# Peartree Hill Solar Farm

## Response to the Examining Authority's Third Written Questions (ExQ3)

Document Ref: EN010157/APP/8.25

November 2025

### Figure 14.2: Transport Routing and the Existing Highway Network

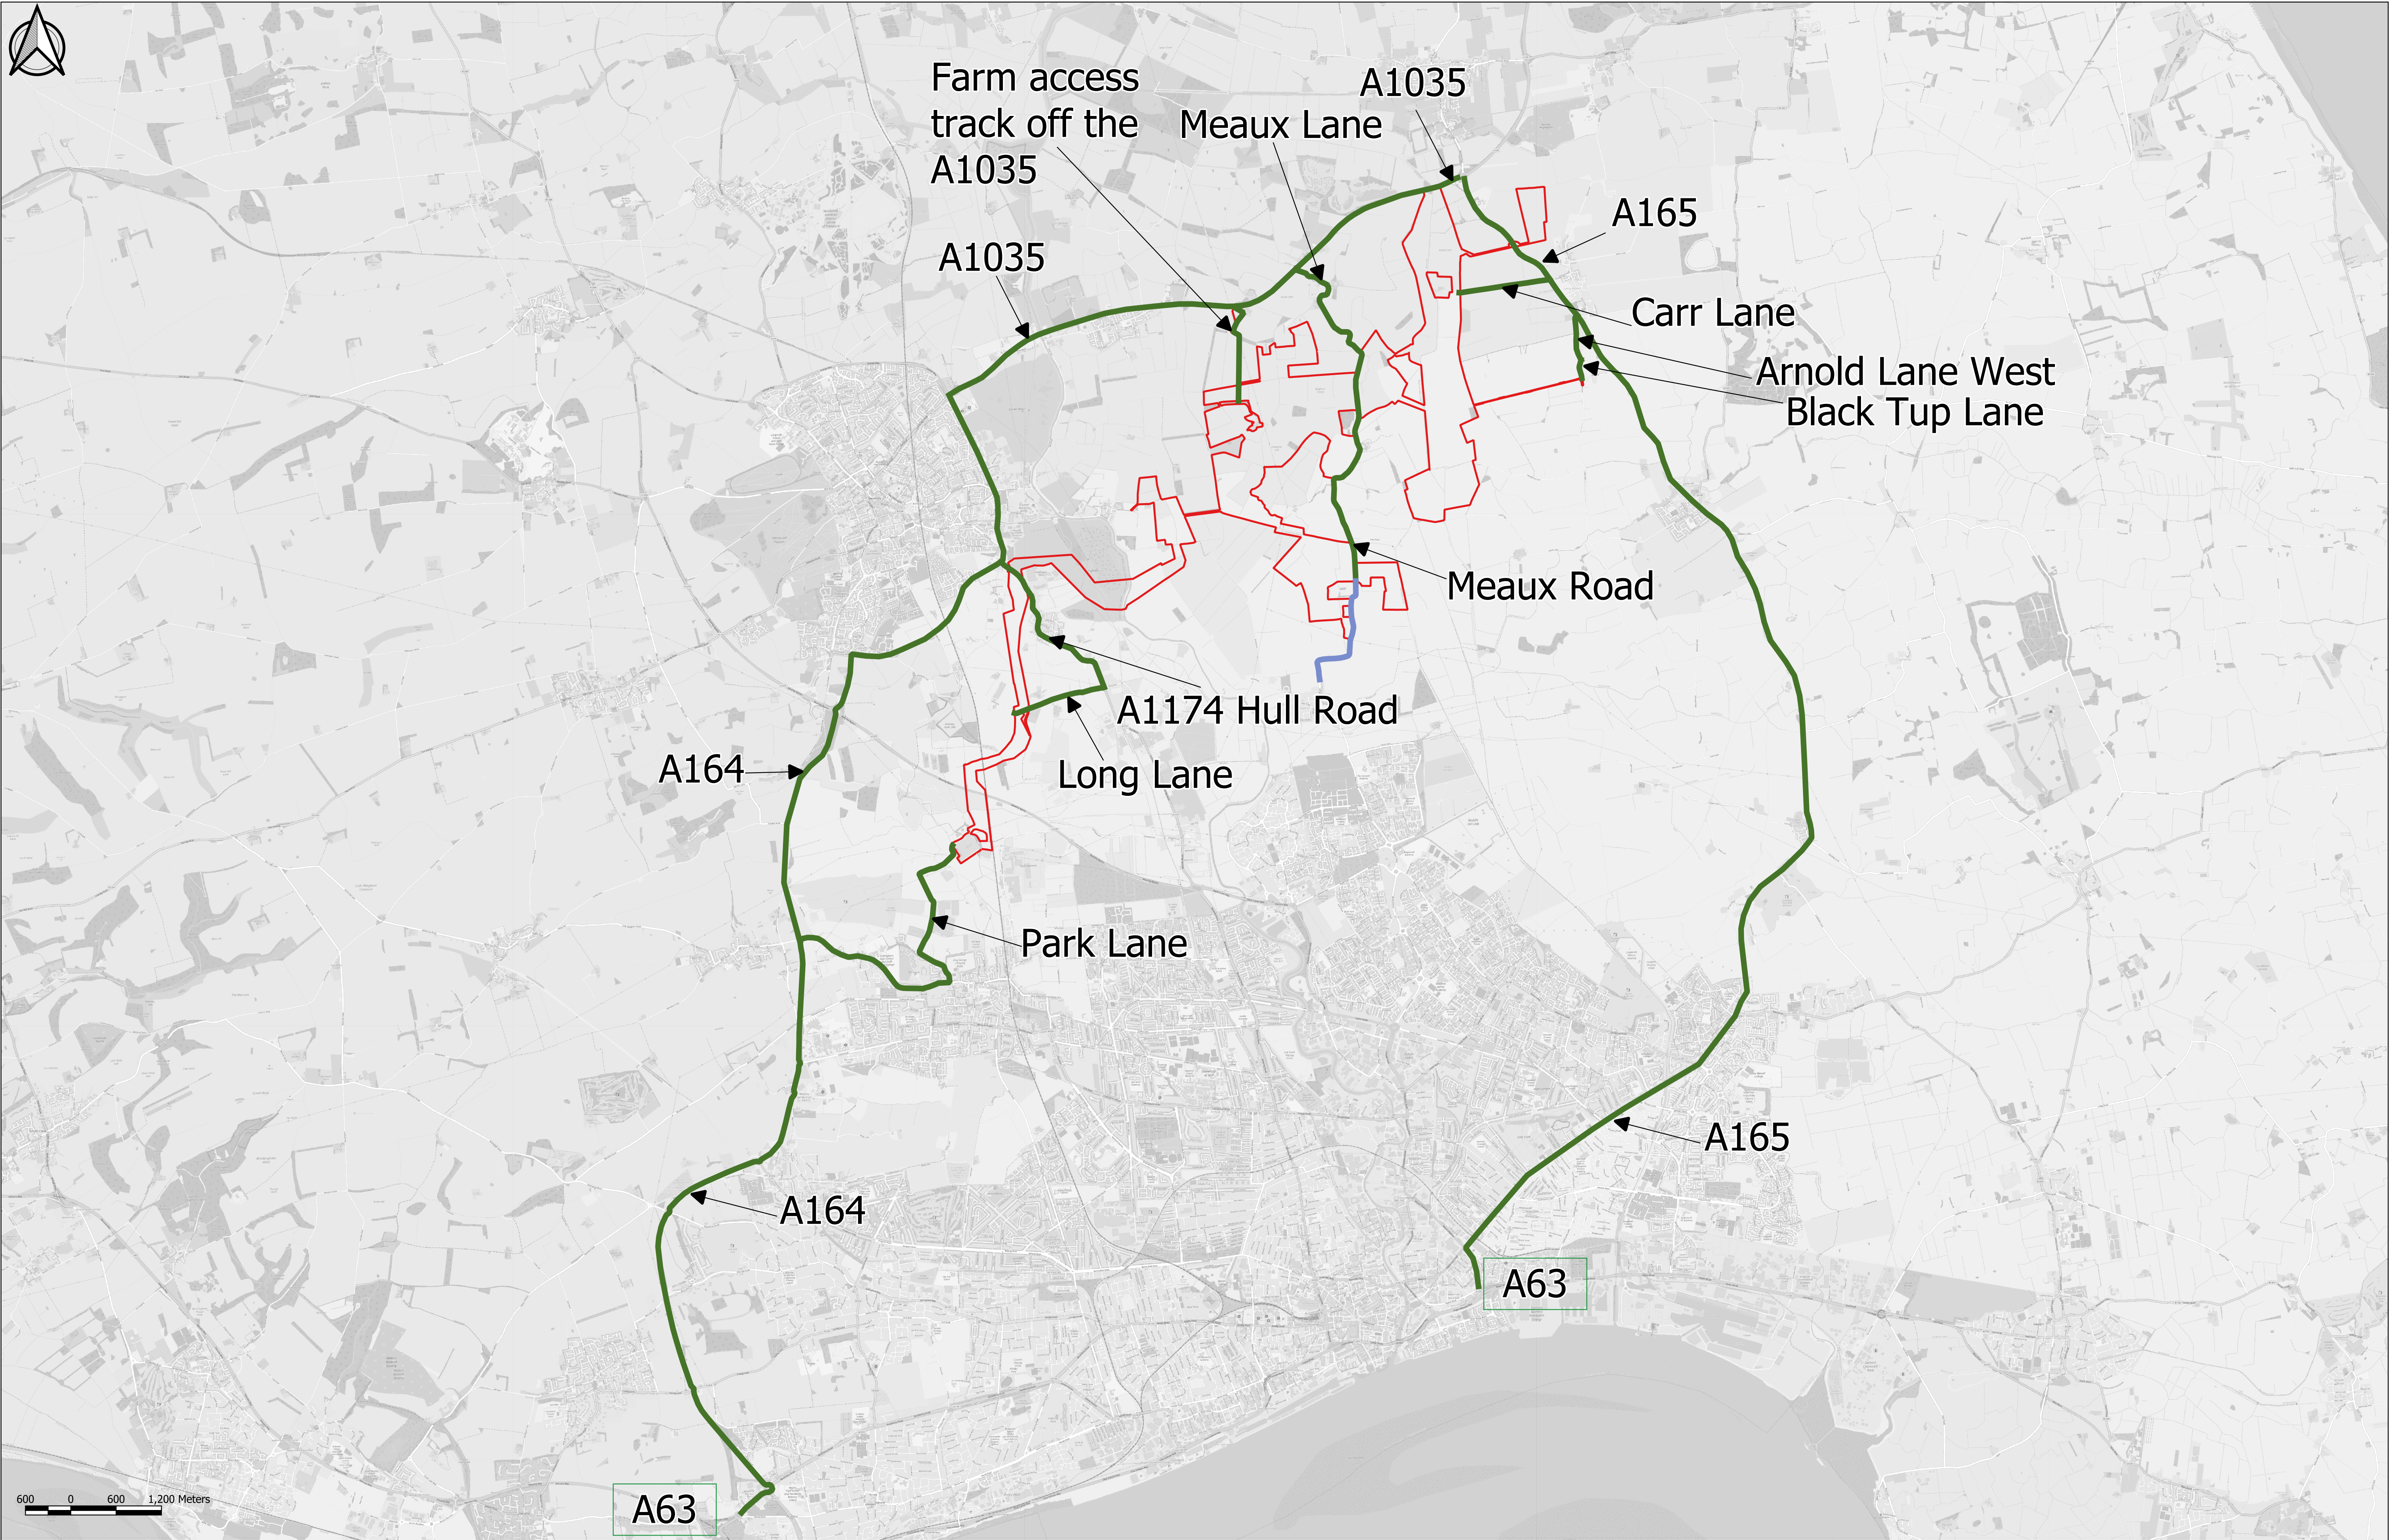
3.5.1	The Applicant	<p><b>Air Quality Management Area (AQMA)</b></p> <p>Notwithstanding your response to ExQ1.5.3 [REP1-073], please:</p> <ul style="list-style-type: none"> <li>a) Clarify which sections of roads identified on ES Figure 14.1: Study Area for Transport and Access [REP2-120] and ES Figure 14.2: Transport Routing and the Existing Highway Network [REP2-121] travel through the AQMA;</li> <li>b) Clarify whether, having regard to Table 6-10 of ES Chapter 6: Air</li> </ul>	<ul style="list-style-type: none"> <li>a) The route A63 showed on <b>ES Volume 3, Figure 14.1: Study Area for Transport and Access [REP2-120]</b> passes through Hull AQMA 1 but the sections of route A63 showed on <b>ES Volume 3, Figure 14.2: Transport Routing and the Existing Highway Network [REP2-121]</b> do not pass through Hull AQMA 1.</li> <li>b) Traffic routing to and from the Site along sections of route A63 as shown on <b>ES Volume 3, Figure 14.2: Transport Routing and the Existing Highway Network [REP2-</b></li> </ul>

3.13.4	The applicant	<p><b>Study area/ transport routes</b></p> <p>Please clarify the relationship/ consistency between the information</p>	<p><b>ES Volume 3, Figure 14.1: Transport and Access Study Area [REP2-120]</b> shows the links within the study area for transport and access, as is outlined in the response to</p>

ExQ3	Question to	Question	Applicants Response
		shown on ES Figure 14.1 [REP2-120] and ES Figure 14.2 [REP2-121].	<p>item 3.13.3 above, the A63 and M62 have been included in the study area text as outlined at paragraph 14.4.5 in <b>ES Volume 2, Chapter 14: Transport and Access [EN010157/APP/6.2 Revision 5]</b>. The study area includes up to the nearest A-class roads and was agreed through consultation with East Riding of Yorkshire Council.</p> <p><b>ES Volume 3, Figure 14.2: Transport Routing and the Existing Highway Network [REP2-121]</b> illustrates the routes for construction vehicles between the Proposed Development and the SRN. Illustrating the vehicle routes up to the SRN is standard practice and at this point it is assumed that vehicles will route to their final destination (assumed to be a port or the wider SRN).</p>
<b>14. Cumulative</b>

ExQ3	Question to	Question	Applicants Response
		<p>Quality [APP-042], any changes in light/ heavy duty vehicle flows through the AQMA would exceed 100/ 25 annual average daily traffic (AADT) respectively;</p> <p>c) If the relevant AADT would be exceeded, provide further justification for a lack of an air quality assessment in this regard and your conclusion that “[...] the road traffic exhaust emissions from the Proposed Development traffic would not cause a significant effect on Hull AQMA 1.”, noting the requirements of NPS EN-1 paragraphs 5.2.8 to 5.2.19; and</p> <p>d) Consider whether any amendments to the Policy Accordance Tables in Appendix 1 of [REP4- 055] or any other documents are necessary in light of the AQMA.</p>	<p><b>121]</b> and described in <b>ES Volume 2, Chapter 14: Transport and Access [REP4-018]</b> paragraphs 14.4.33 and 14.4.34 will not pass through Hull AQMA 1. Therefore, Proposed Development traffic data has not been compared with the screening criteria (within an AQMA) presented in <b>Table 6-10 of ES Volume 2, Chapter 6: Air Quality [EN010157/APP/6.2 Revision 2]</b>.</p> <p>c) As mentioned above, traffic routing to and from the Site along sections of route A63 will not pass through Hull AQMA 1. The existing traffic volumes on the A63 are higher than the roads within the study area which will result in the impact of Proposed Development traffic being diluted. It is considered that the road traffic exhaust emissions from the Proposed Development traffic will not cause a significant effect on Hull AQMA 1.</p>

ExQ3	Question to	Question	Applicants Response
			d) Amendments to documents are not considered necessary based on the responses above.
<b>6. Biodiversity (including Habitats Regulations Assessment (HRA))</b>
